DRB CASE ACTION LOG (SITE PLAN FOR BUILDING PERMIT)
REVISED 9/28/05

DRB Application No.: <u>07DRB-70196(SBP)</u>	Project # <u>1005484</u>
Project Name: <u>RIVERVIEW PARCELS</u>	
Agent: <u>MULLEN HELLER ARCHITECTURE PC</u>	Phone No: <u>268-4144</u>

**City of Albuquerque
Planning Department
Inter-Office Memorandum**

To: Sheran Matson, DRB Chair
From: Carol Toffaleti, Planner 
Date: August 21, 2007
Subject: Project # 1005484 / 07EPC-00433 – Golf Course Rd.

4 West Elevation  
Scale: 1/8"=1'-0"

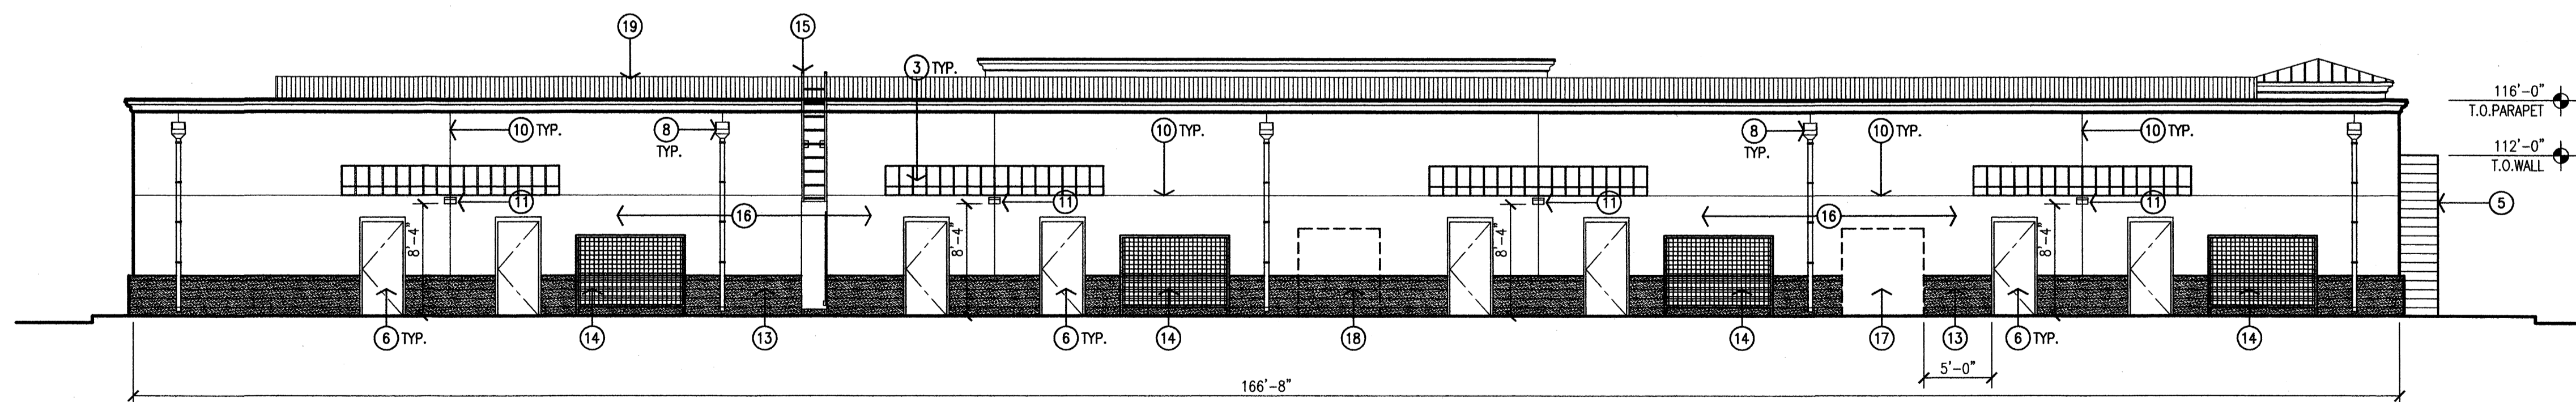
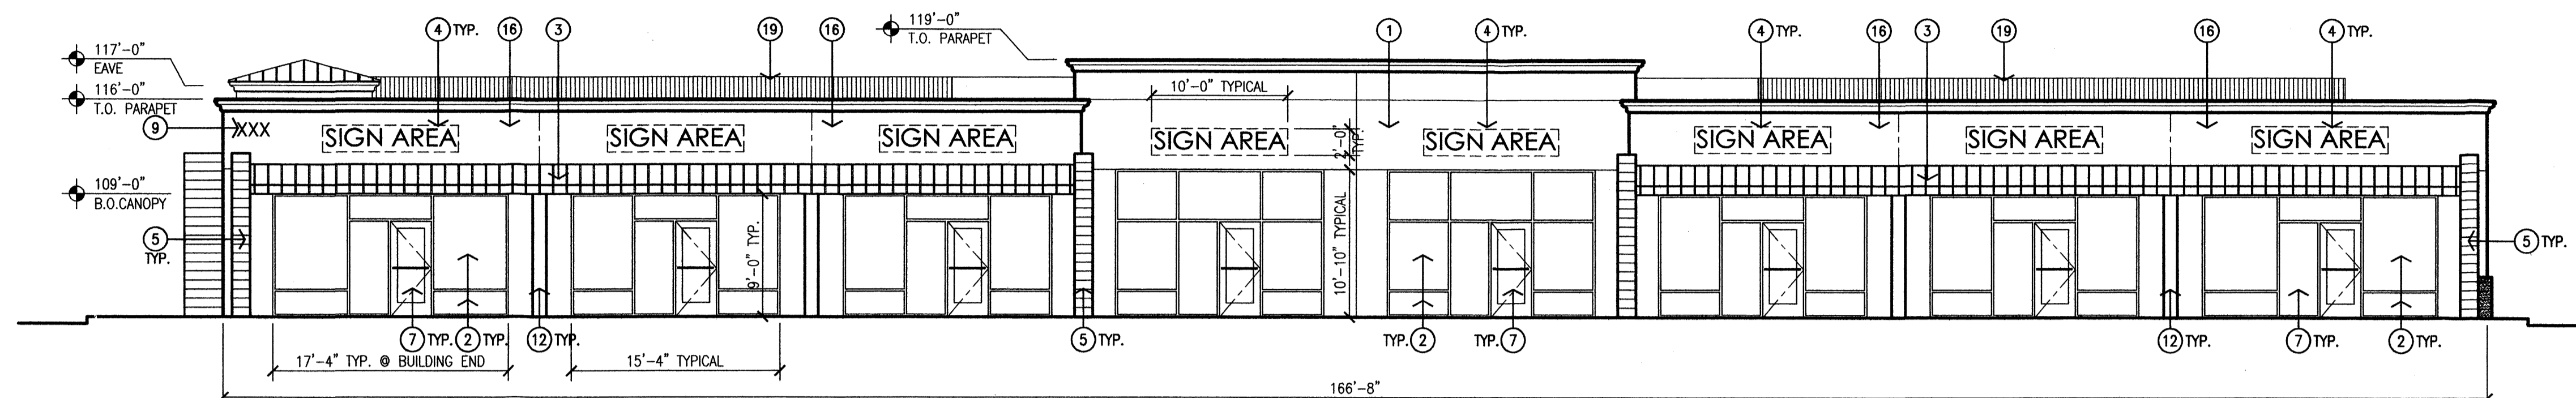
g. Trellises on west side of building

The location and width of the trellises does not match the elevations. Because the EPC did not approve a landscaped strip along the west easement and there is insufficient space for both a landscaped strip and trellises, Staff has asked the applicant to provide trellises and honeysuckle only at the locations indicated on the elevations.
